ADDENDUM TO CHAPTER 5 BIODIVERSITY

This Addendum to Chapter 5 Biodiversity of the EIAR (dated June 2024) submitted to Kildare County Council as part of the planning application for the Project on 13th August 2024, updates the biodiversity assessment of the Project, in response to the Kildare County Council (KCC) RFI.

NI2615 | Herbata Data Centre, Naas | 01 | June 2025

1 A1400 - PROPOSED BOUNDARY AND FENCING PLAN
1 : 2000

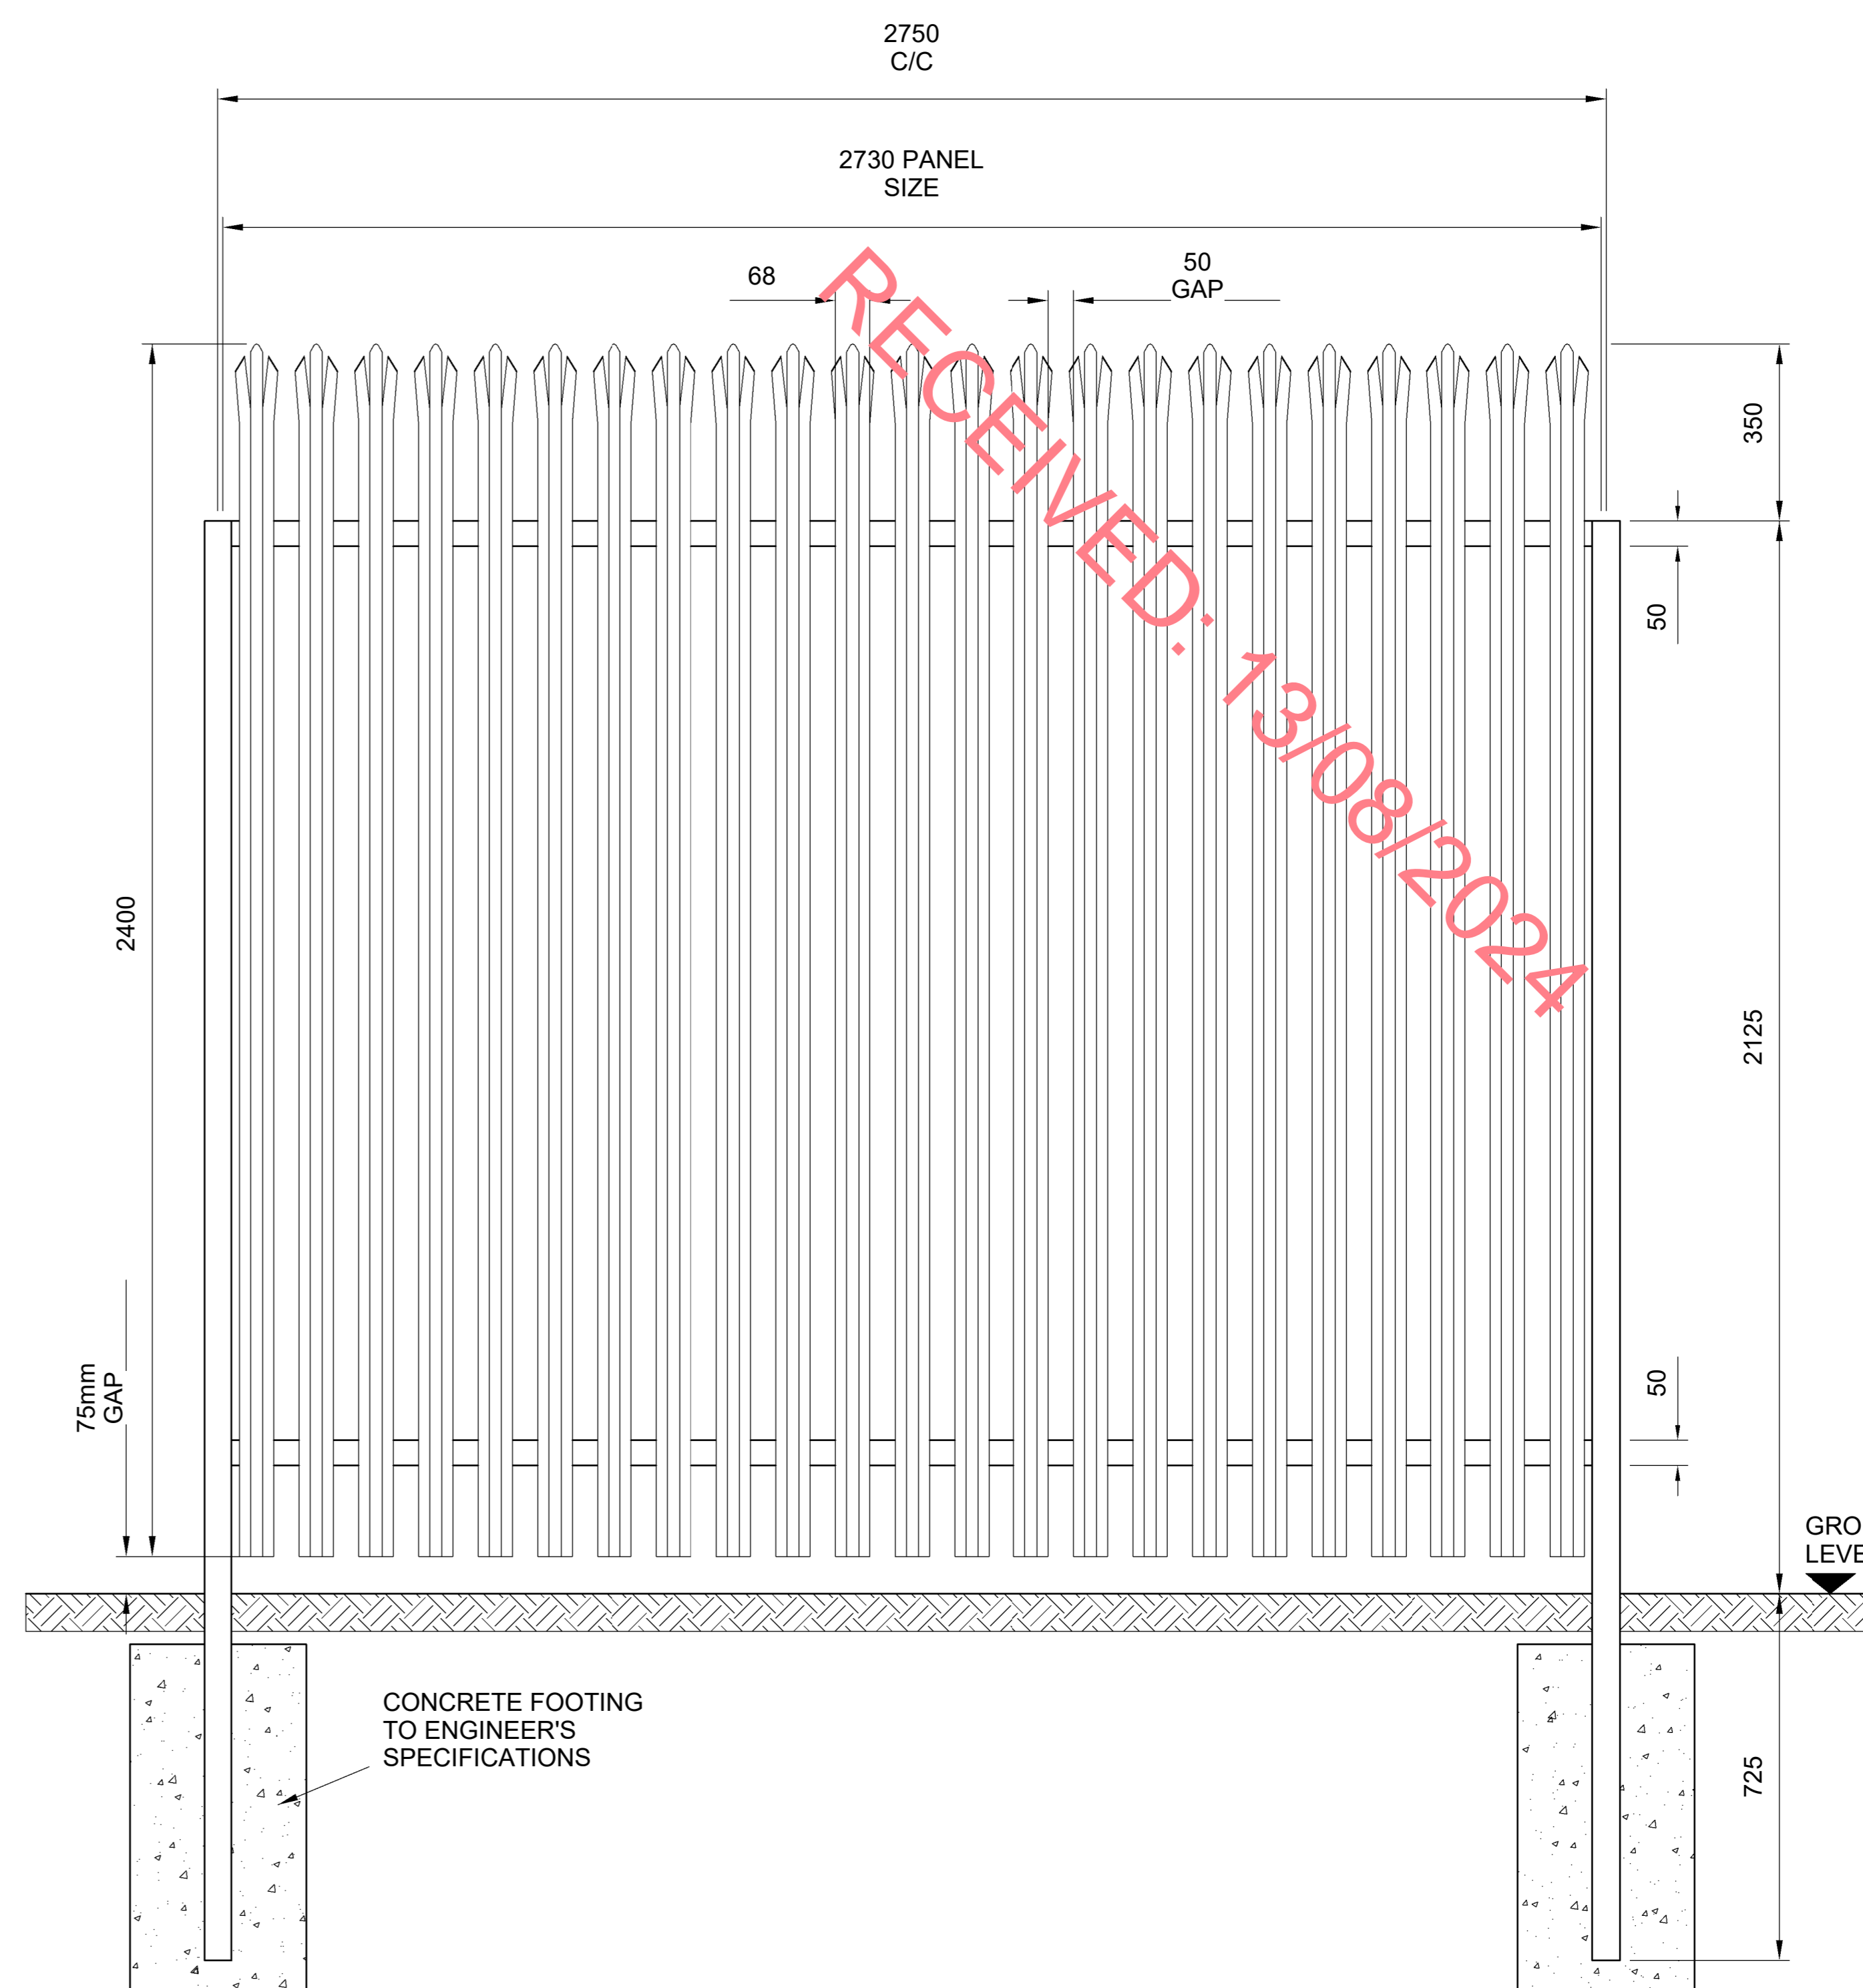
In consideration of the request for inclusion of a fencing arrangement *to allow for wildlife access and passage through the site*, an amendment has been made to the proposed Landscape Masterplan to include mammal passes in fences throughout the full extent of the site. The number, location and dimensions of the mammal passes was established following engagement between the project ecology and landscape team. The inclusion of the mammal passes has not required changes to the submitted landscape planting proposals.

Mammal passes are proposed at locations throughout the site including all *perimeter* fences and *internal* fences within the site (for example around each Data Centre building). The gap at the foot of the proposed fencing, of 500mm (width) x 200mm is sufficient for all potential mammal species and will ensure access and passage throughout the site, in line with the request from Kildare County Council. There are no proposed amendments to the overall height, materials or layout of the proposed fencing.

2 A1400 - PALISADE SECURITY FENCE
1 : 10

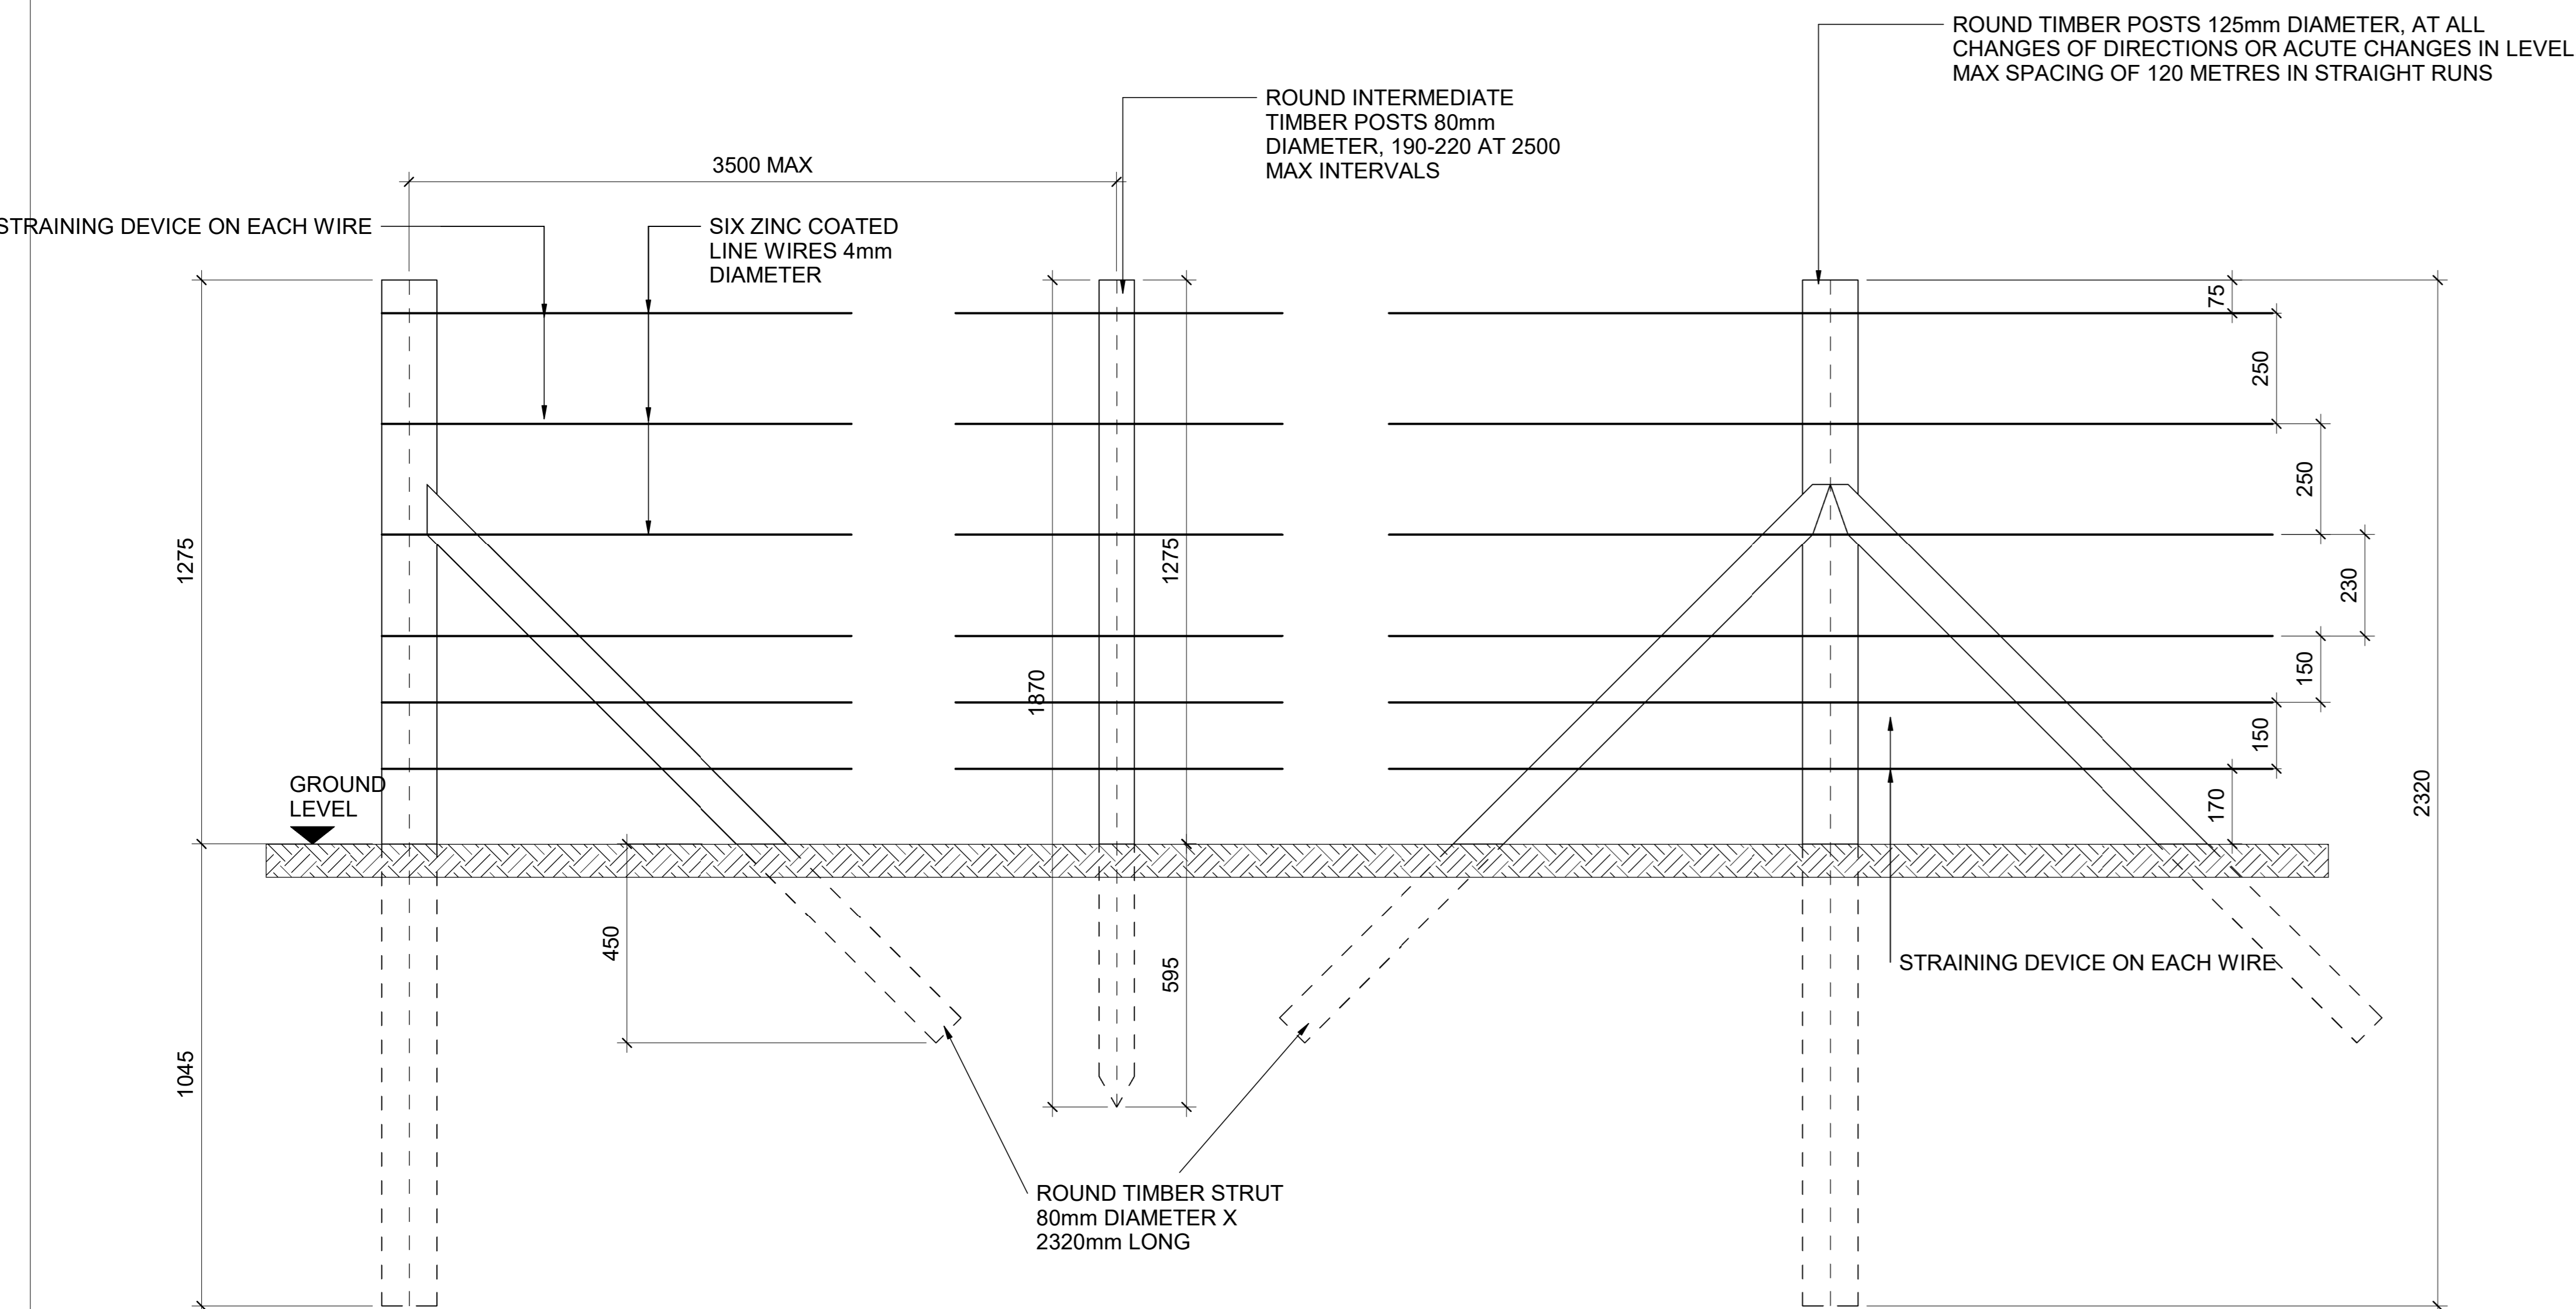
Figure 5.1 below (extract of drawing number BSM-ZZ-ZZ-DR-L-0311 Landscape Boundary Treatments Plan) illustrates the location of the mammal passes; Figure 5.2 below (extract of drawing number 22217-RKD-ZZ-ZZ-DR-A-1400 Proposed Boundary and Fence Details) illustrates the detailed dimensions of the fencing.
